Response to Planning application from Hertfordshire County Council (T and CP GDP Order 2015)

District ref: 6/2022/2409/OUTLINE
HCC ref: WH/14451/2022
HCC received: 28 October 2022
Area manager: Manjinder Sehmi
Case officer: Melvin Andrews

Brookmans Park Golf Club, Golf Club Road, Hatfield AL9 7AT

Outline permission for the erection of 9 dwellings, with all matters reserved except for access.

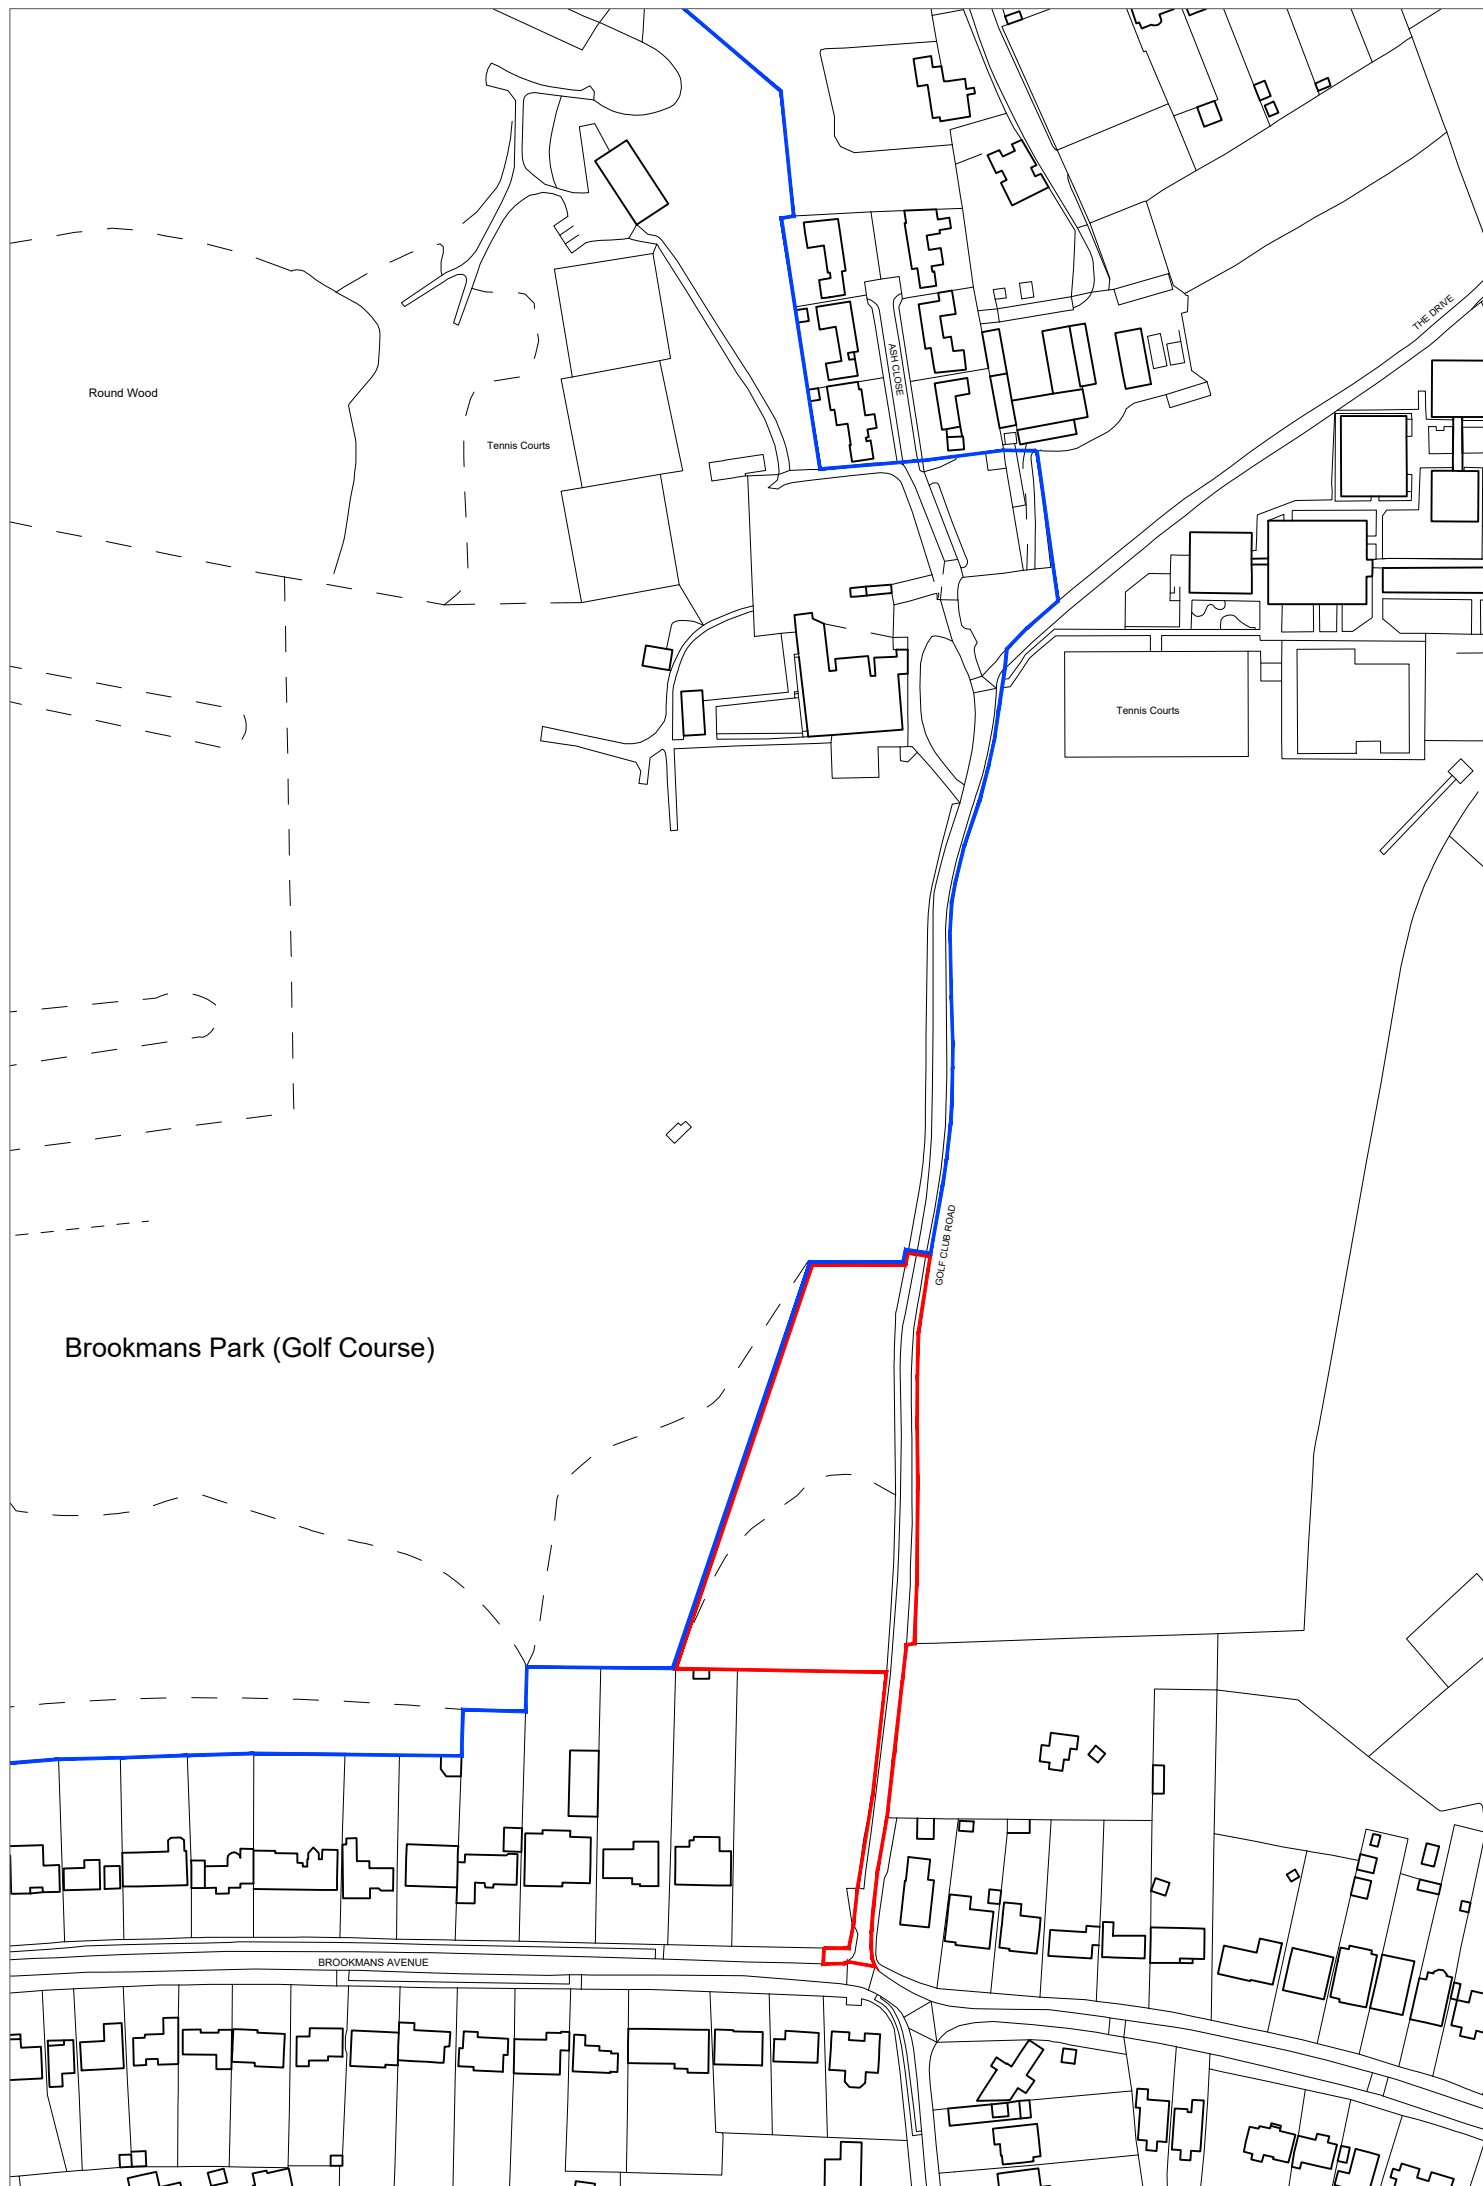
The applicant also shows a separate vehicular access for dwellings 4,7,8 and 9. Highways would prefer to see an option where there is one access for the site rather than multiple accesses. The

proposed new priority junction should serve all new dwellings off Golf Club Road for reasons concerning highway safety.

- The speed humps are extended further north along Gold Club Road with a potential 2 additional humps (60m apart)
- The extent of the proposed footpaths should be shown in more detail on the above drawing for highway review
